TfNSW Reference: SYD20/00506/03

DPIE Reference: SSD 10457

**EXHIBITION OF EIS FOR STAGE 3 EASTERN CREEK RETAIL OUTLET CENTRE-  
EASTERN CREEK BUSINESS HUB**

Title
**INTERSECTION LAYOUT - WORKS PLAN
SHEET 2 OF 2**

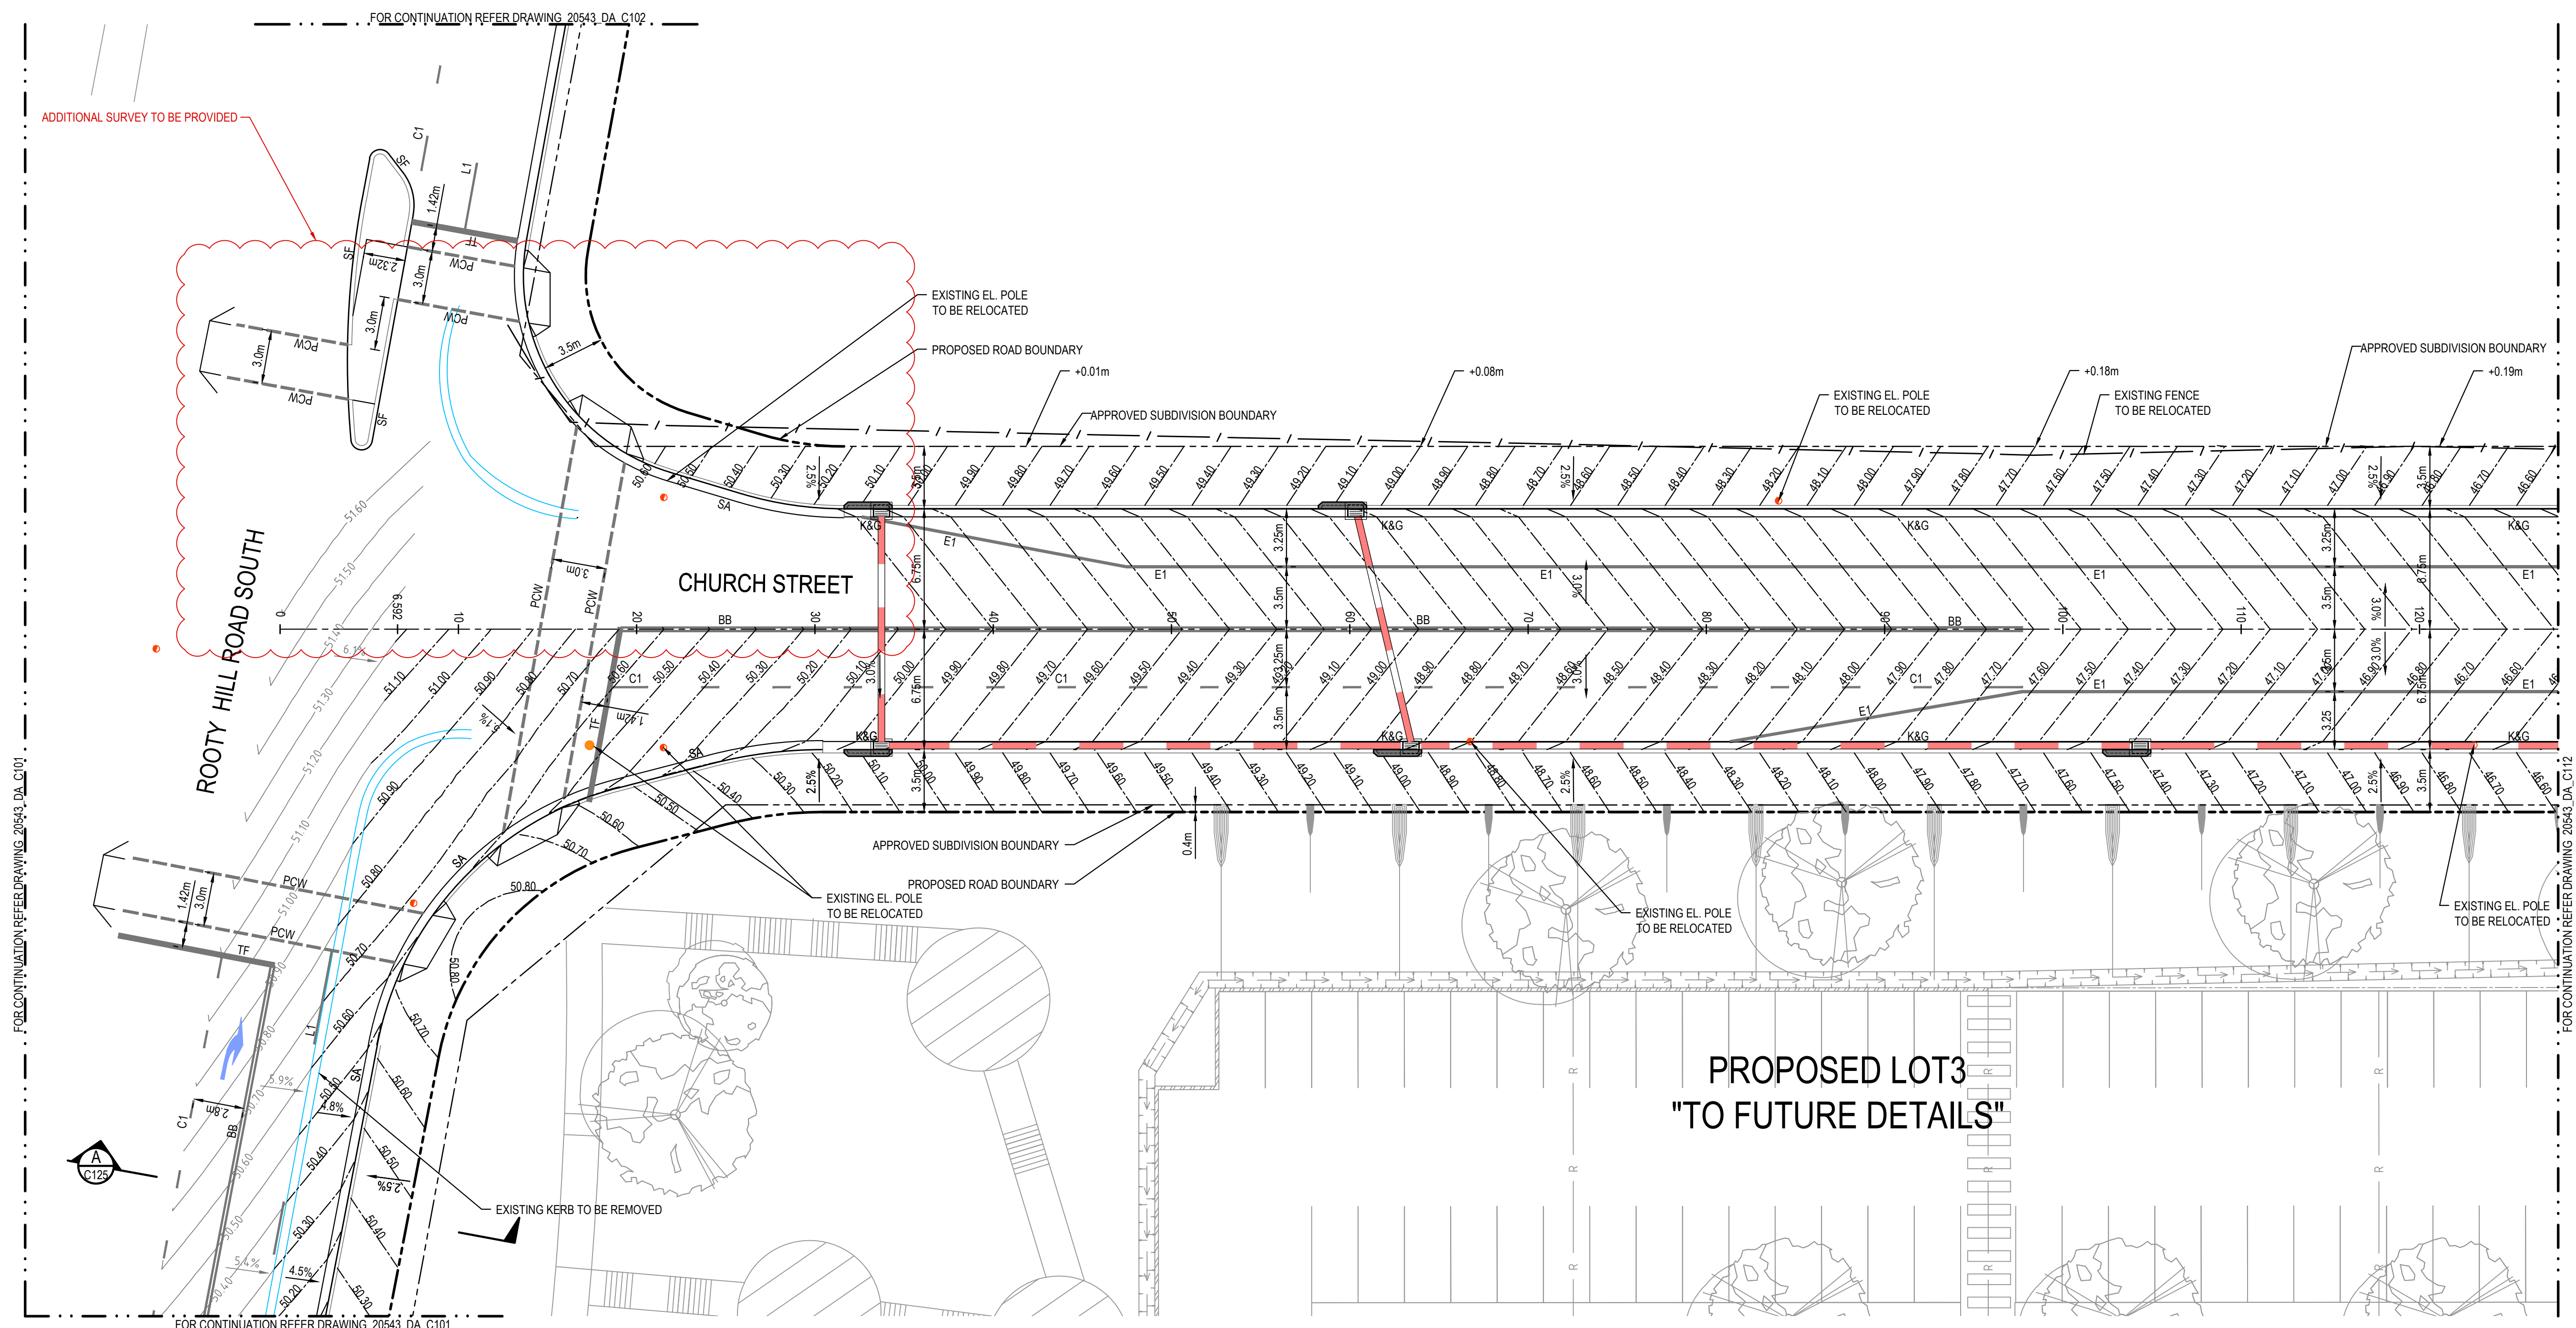
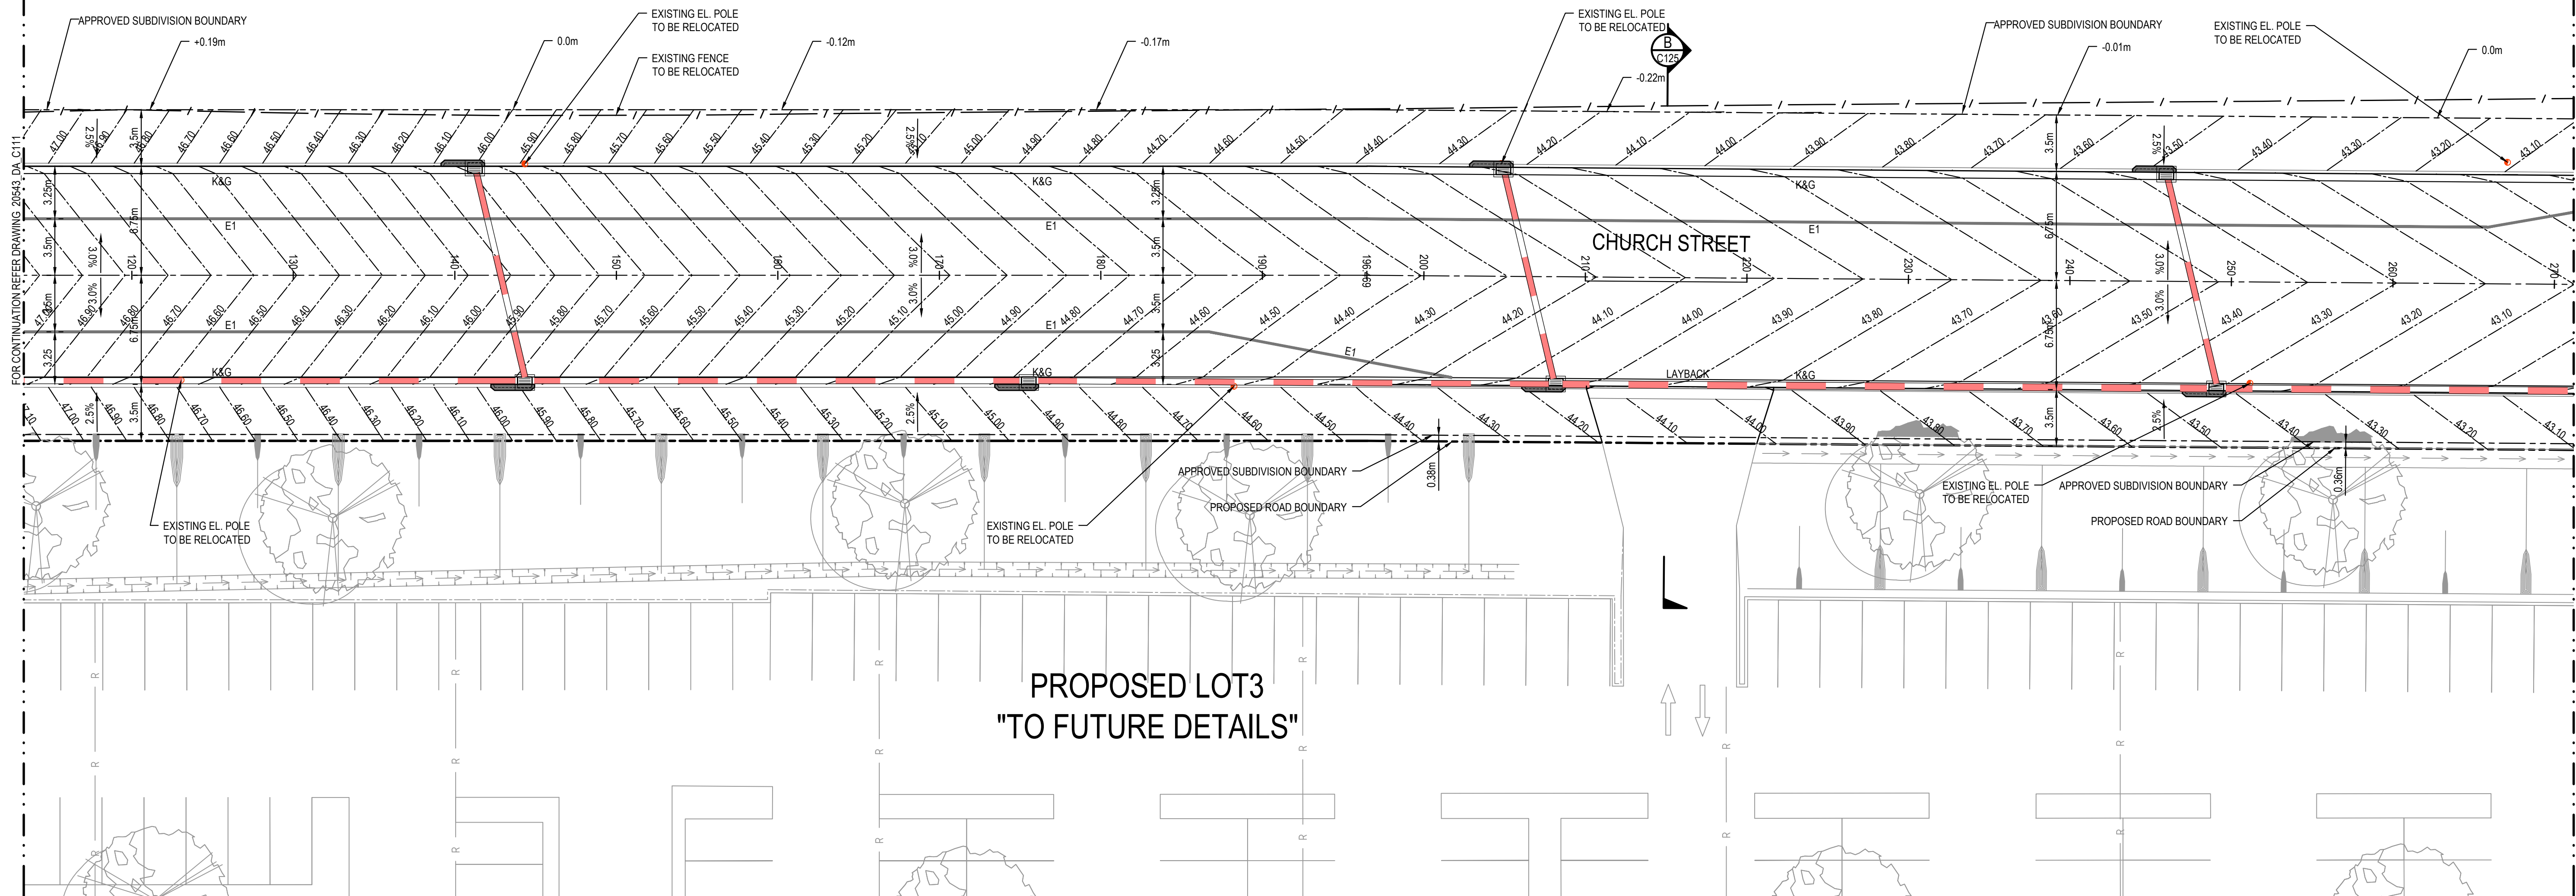
1. TfNSW does not support the proposed traffic signals at the Rooty Hill Road South and Church Street intersection. Sections 5.4 and 5.5 in the submitted Traffic Report do not include a warrants assessment in accordance with Section 2 of the Traffic Signal Design Guide. It is also not clear whether the warrants will be met in future. As such, the vehicular access at the Church Street and Rooty Hill Road South intersection should be left-in/left-out.

3. The first vehicular access on Church Street closest to the intersection with Rooty Hill Road South is not supported due to potential queuing impacts on Rooty Hill Road South. All vehicular access should be provided at the northern boundary of the site.

Figure 4: Vehicle access

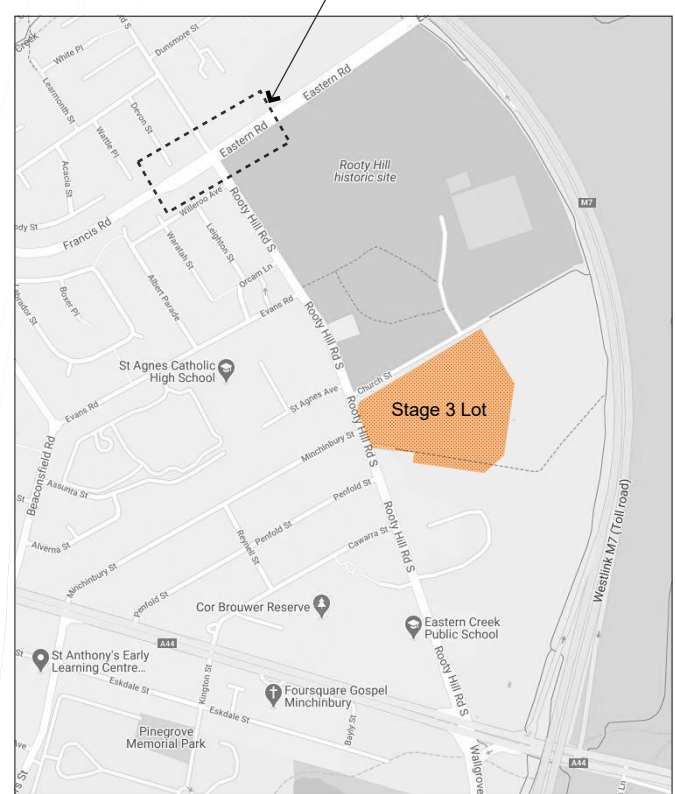
2. The proposed modifications to the Francis Street/Eastern Road/Rooty Hill Road South intersection in section 6.25 of the Traffic Report are not supported by TfNSW. Currently the left turns are the predominant movement at this intersection and the proposal would affect capacity for these movements and hence not supported.
